DRB Application No.: 06DRB-01218 ~~FP~~
 Project Name: GRANADA HEIGHTS LOT 3A-1
 BLOCK 3
 Agent: Isaacson & Arfman PA

ISAACSON & ARFMAN agent(s) for 207 ALISO DRIVE LLC request(s) the above action(s) for all or a portion of Lot(s) 3A & 4, Block(s) 3, GRANADA HEIGHTS (to be known as **LOT 3A-1, BLOCK 3, GRANADA HEIGHTS**) zoned R-2 residential zone, located on ALISO DR SE, between SILVER AVE SE and ARLOTTE AVE SE containing approximately 1 acre(s). [REF: 06DRB-00393] *[Final Plat was Indef deferred for the SIA 8/30/06]* (K-17) **THE FINAL PLAT WAS APPROVED WITH FINAL SIGN OFF DELEGATED TO PLANNING FOR REAL PROPERTY'S SIGNATURE AND AGIS DXF FILE.**

9. Project # 1004779
06DRB-01218 Minor-Prelim&Final Plat Approval
06DRB-01219 Minor-Temp Defer SDWK

Final Plat
Preliminary Plat
Sidewalk Deferral

SCALE: 1" = 20'
 PROJECT NO. 0606PB15
 DRAWN BY: JRT
 ZONE ATLAS: K-17-Z
 GRANADA.CR5

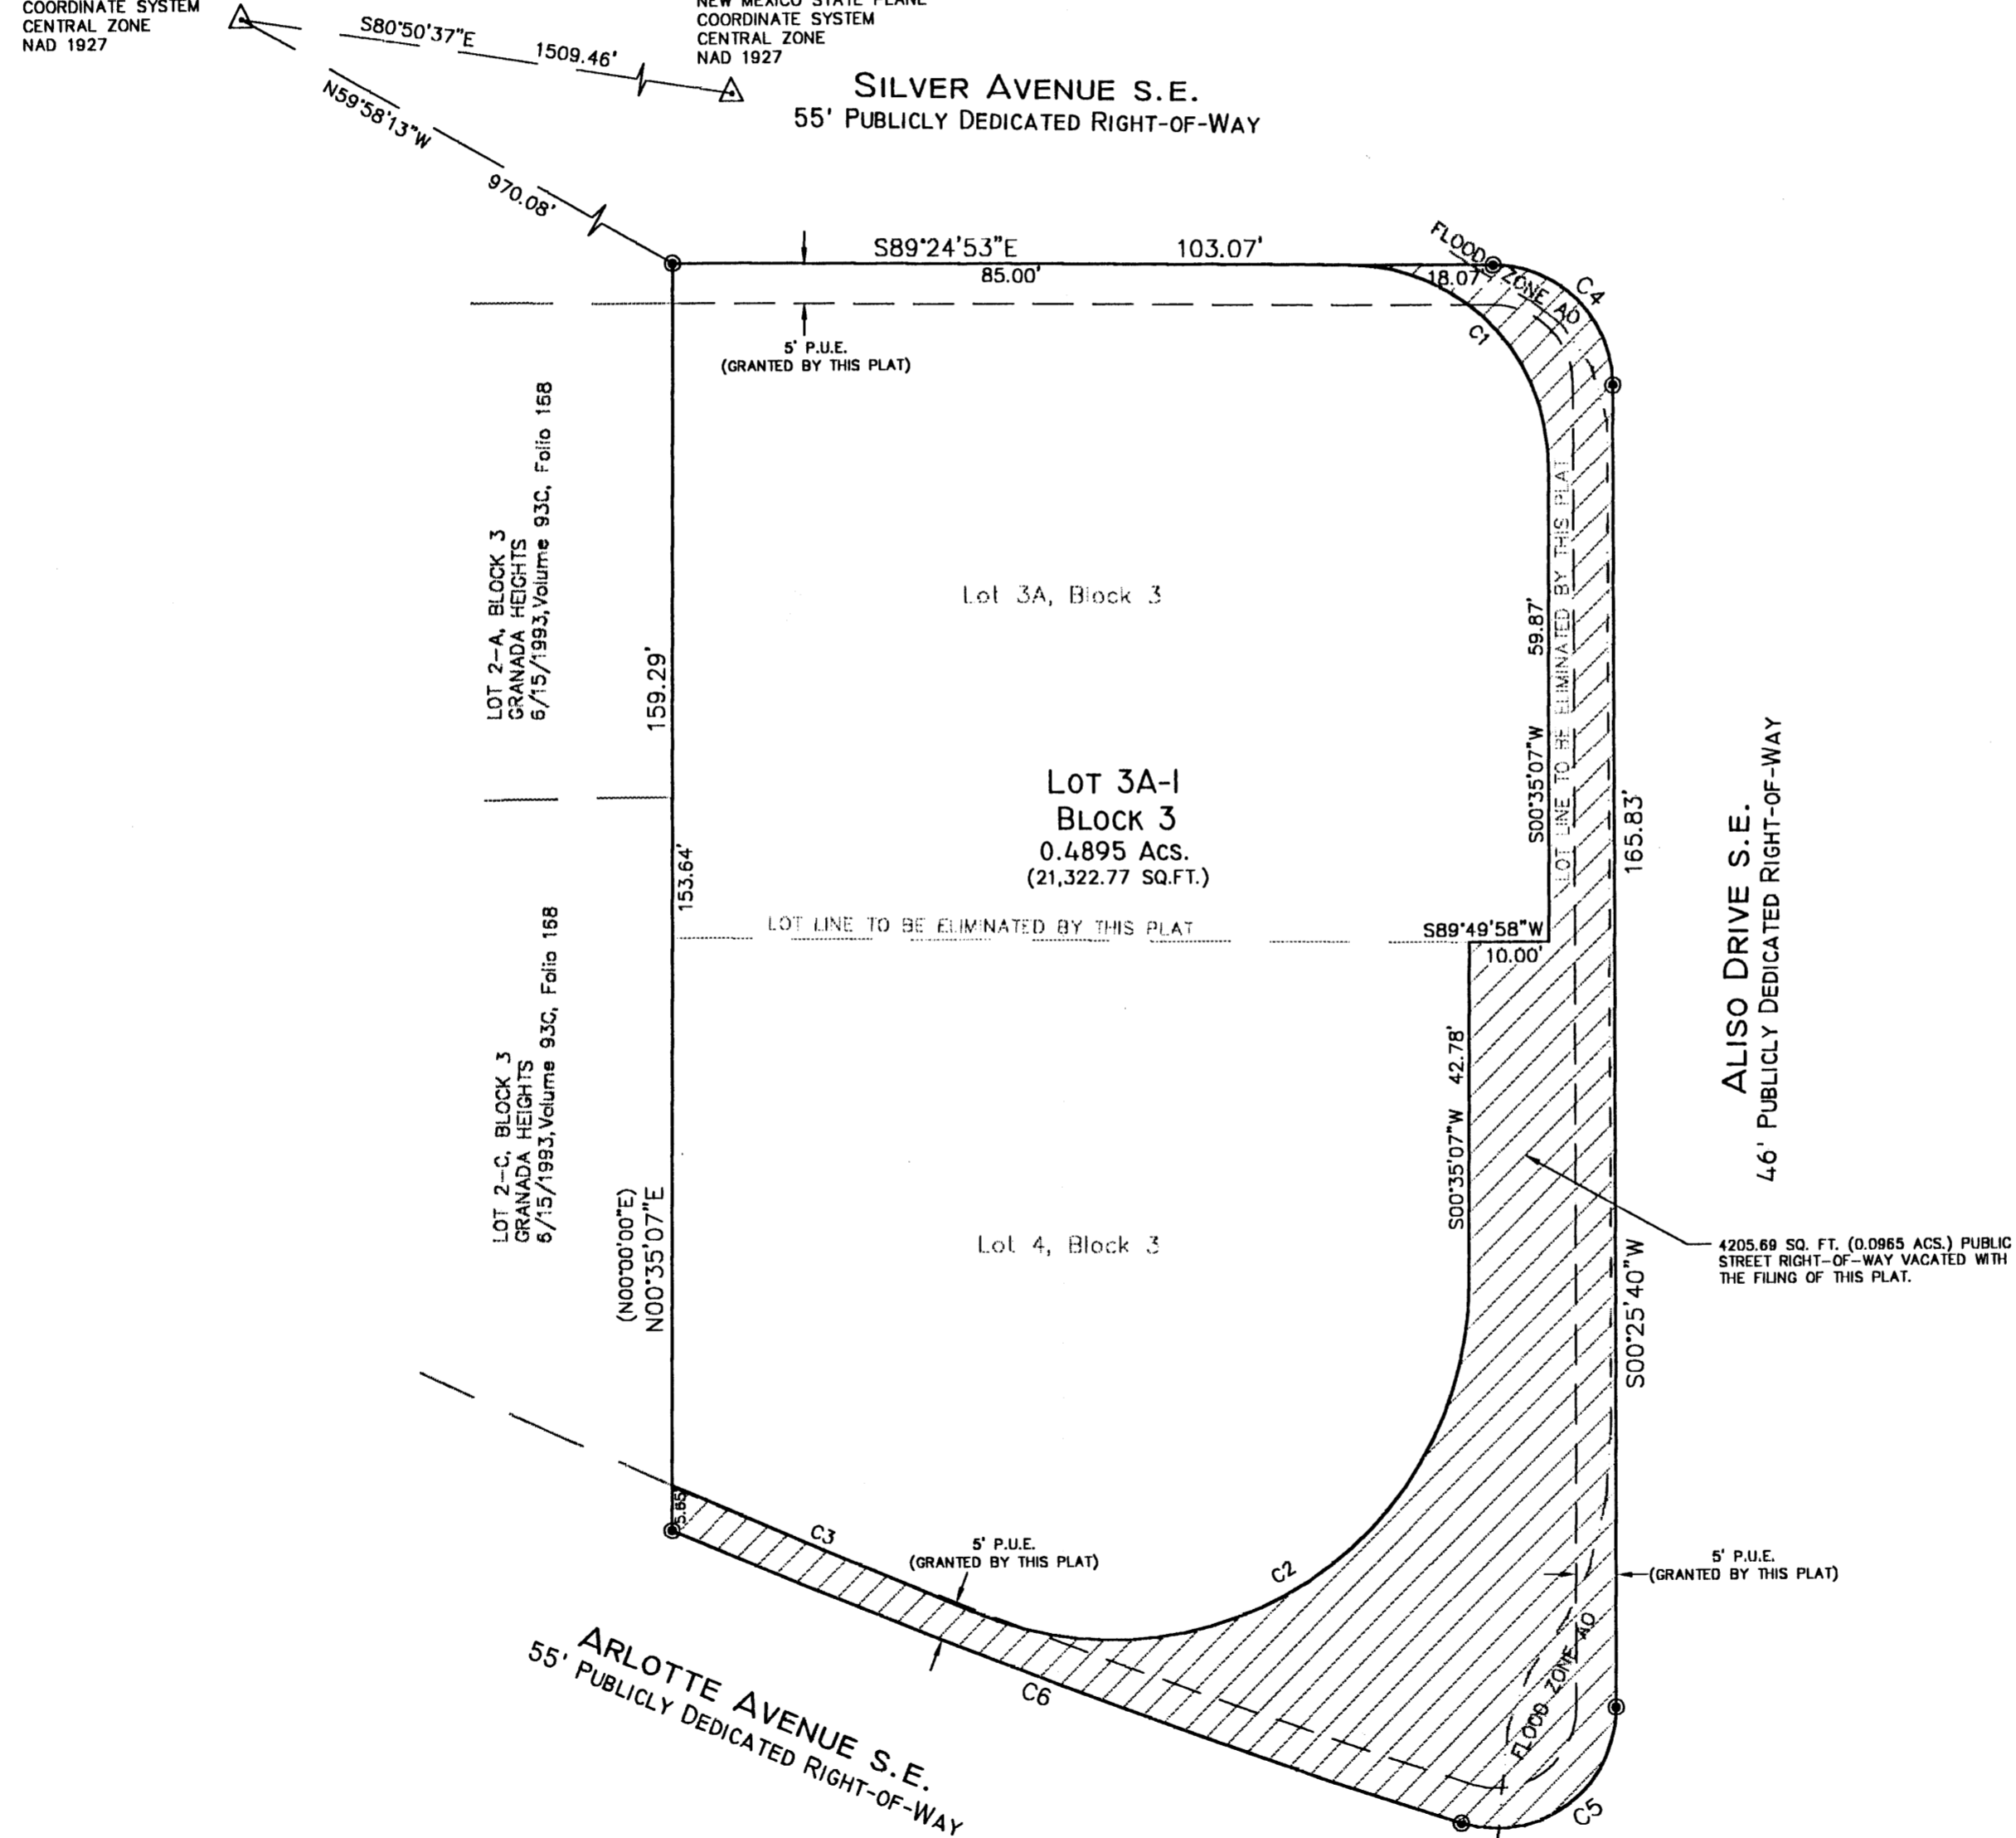
- ✓ Show the floodplain on the lot.
- ✓ The easements shall be retained for existing public water/sewer lines as determined prior to final plat approval.

Must show floodplain on plat.
